WEST SUSSEX COUNTY COUNCIL CONSULTATION

TO:	Arun District Council FAO: Mrs A Gardner
FROM:	WSCC - Highways Authority
DATE:	17 December 2020
LOCATION:	Laundry 38 Oakhurst Gardens Rustington Littlehampton BN16 3AN
SUBJECT:	R/227/20/PL Demolition of existing laundry building, lean to & shed, construction of a ground & first storey accommodation building housing 3 No. sheltered housing flats & construction of a single storey laundry building including upgrade of associated clothes drying area & surrounding landscaping. This site is in CIL Zone 5 (Zero Rated) as sheltered housing.
DATE OF SITE VISIT:	n/a
RECOMMENDATION:	Advice
S106 CONTRIBUTION TOTAL:	n/a

Project	Laundry & Accommodation Oakhurst Gardens	Project No.	010
Client	Littlehampton & Rustington Housing Society	Date	Drawn ES
Scale / Format	1:250 @ A1 1:500 @ A3	Checked JT	Issue P1
CAD Reference	Approved SM	Drawing No.	010-X-10-02
Drawing Name	Proposed - Block Plan

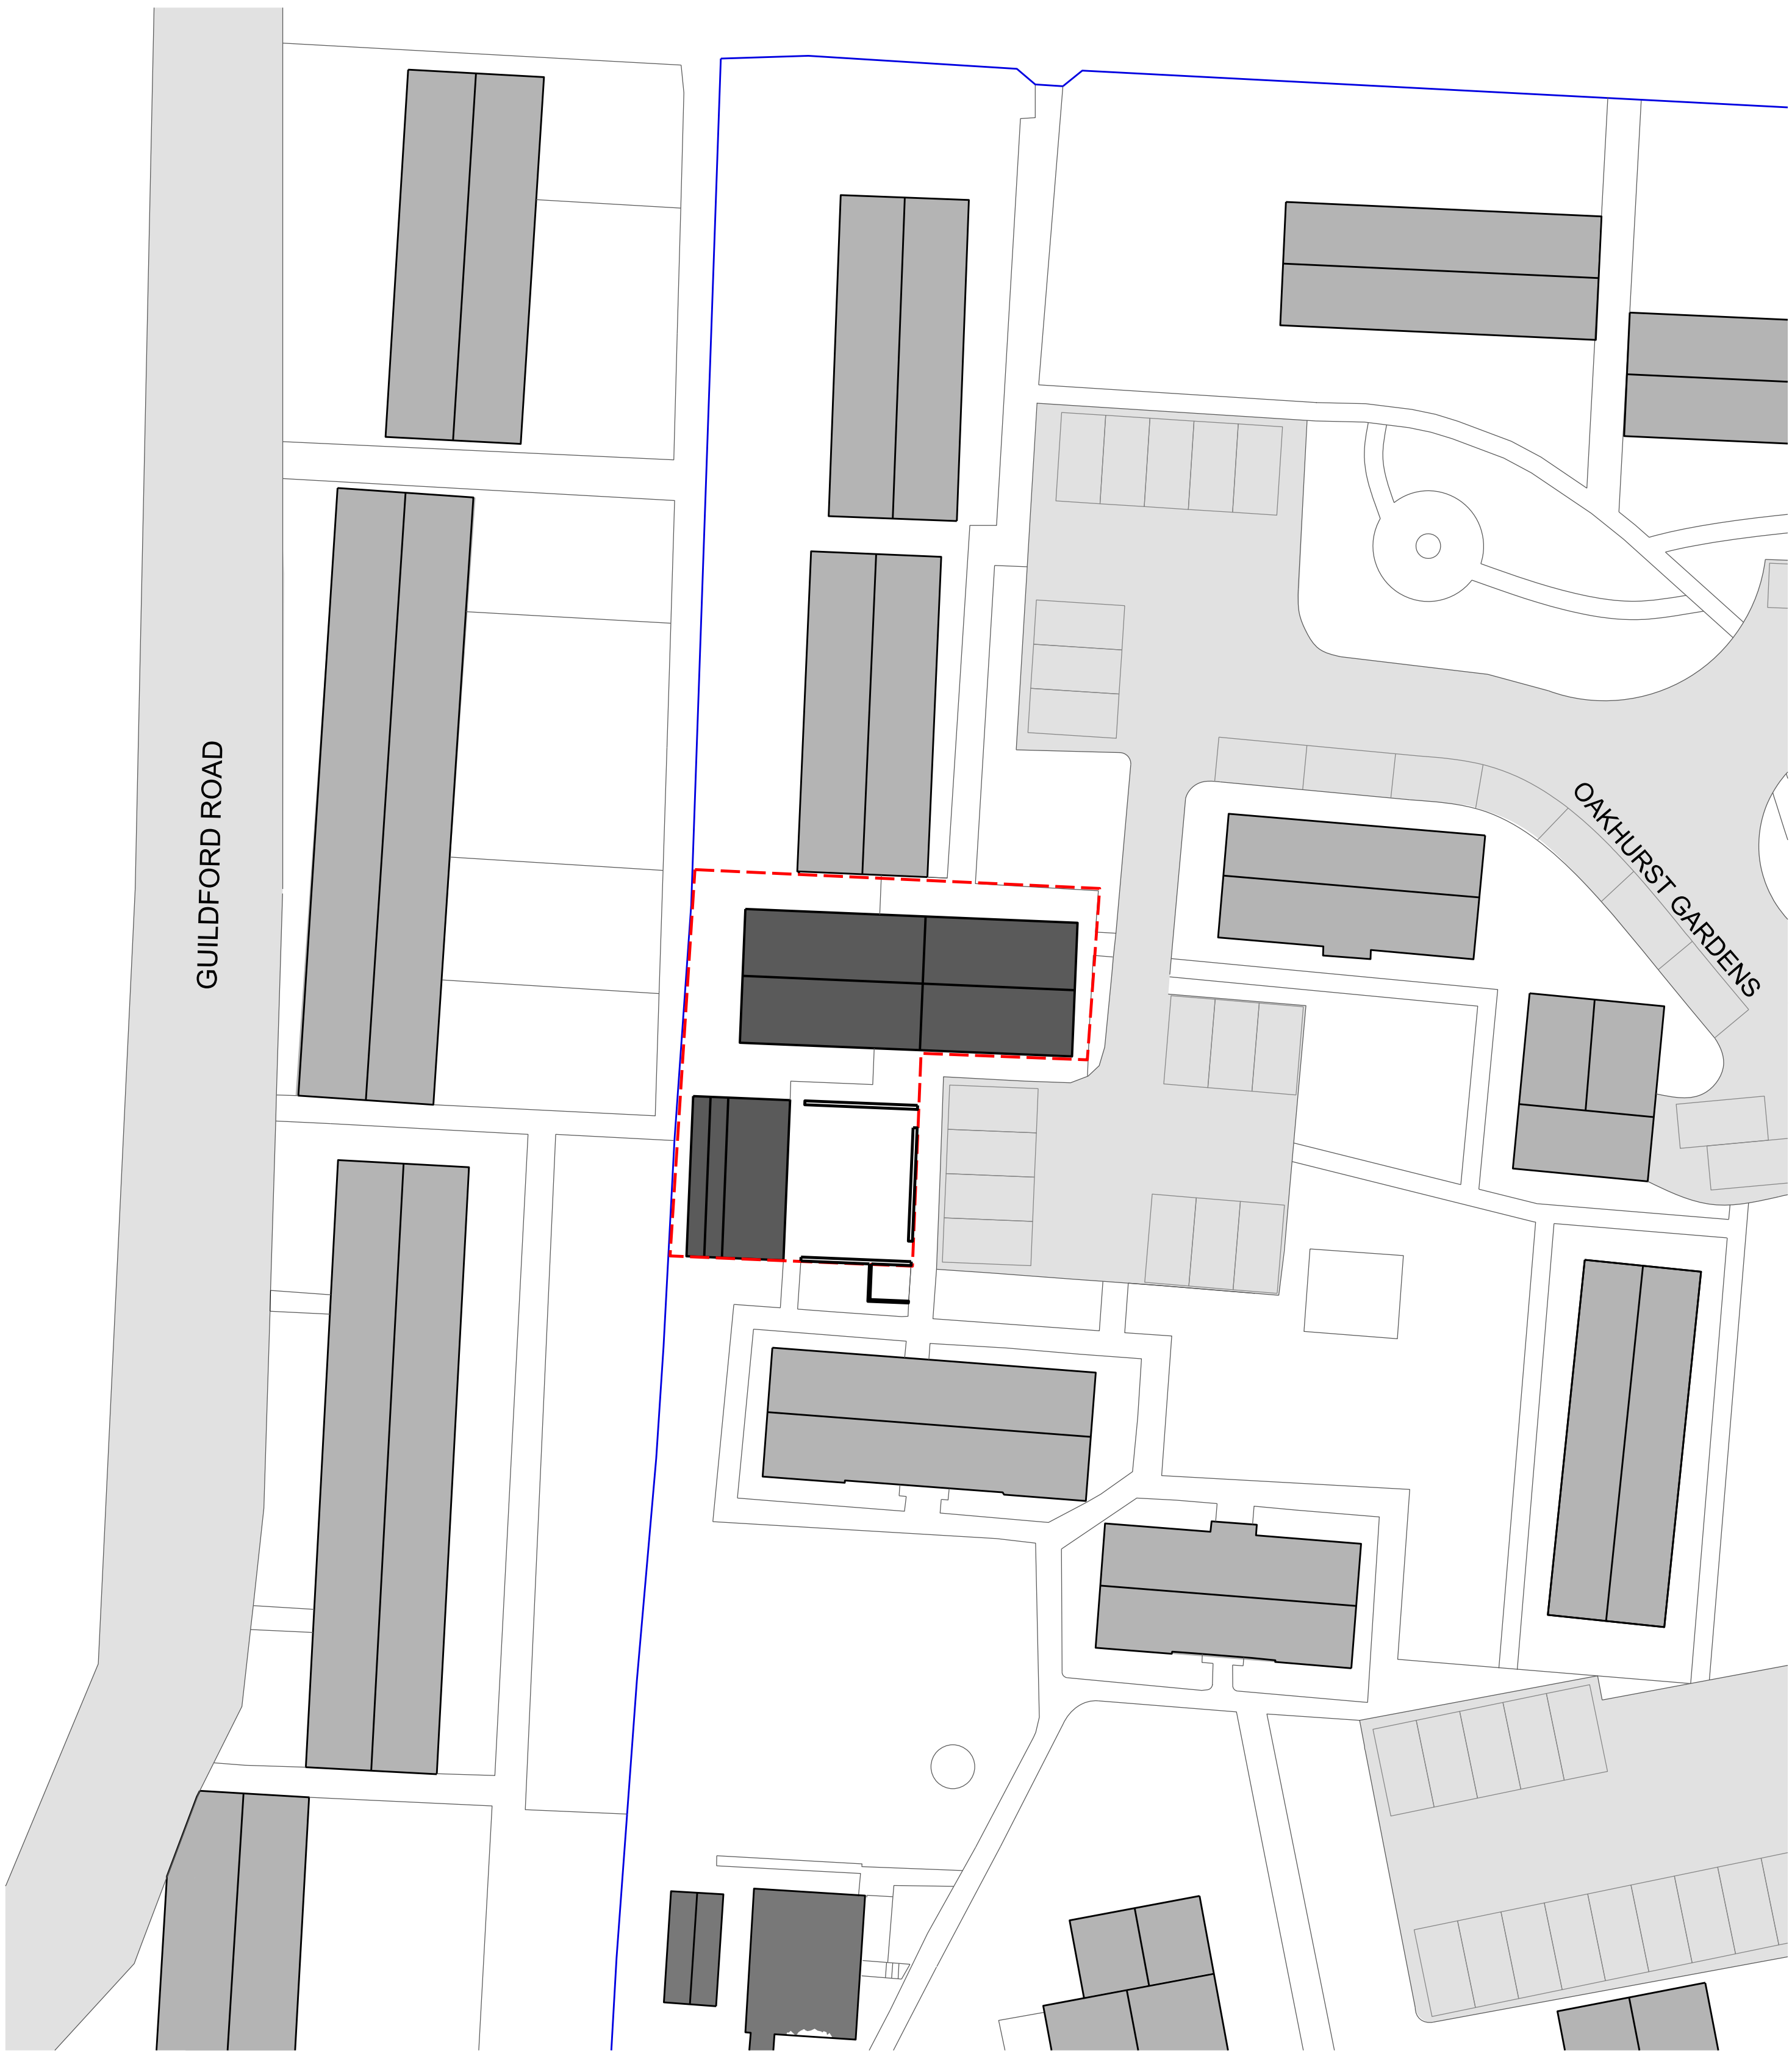
An existing parking area will be re-arranged and extended to create 2 additional spaces.

The spaces are considered suitably sized and given suitable manoeuvring room.

Arun District Council parking guidance require 2 spaces per 1 bed dwelling in a location such as this, a total demand of 6 spaces. As a result, it would be anticipated that the gain in spaces provided (2 spaces) is short by 4 spaces. No data has been provided pertaining to the existing pressure on parking within the wider sheltered housing complex. The site is also located away from the public highway, it would therefore not be anticipated that any overspill parking will take place or impact upon the public highway.

The LPA may wish to consider the amenity concerns or require further information to demonstrate that the existing parking provision is not under pressure and can accommodate the additional demand created.

No part of the development shall be first occupied until the car parking has been constructed in accordance with the approved site plan. These spaces shall thereafter be retained at all times for their designated purpose.
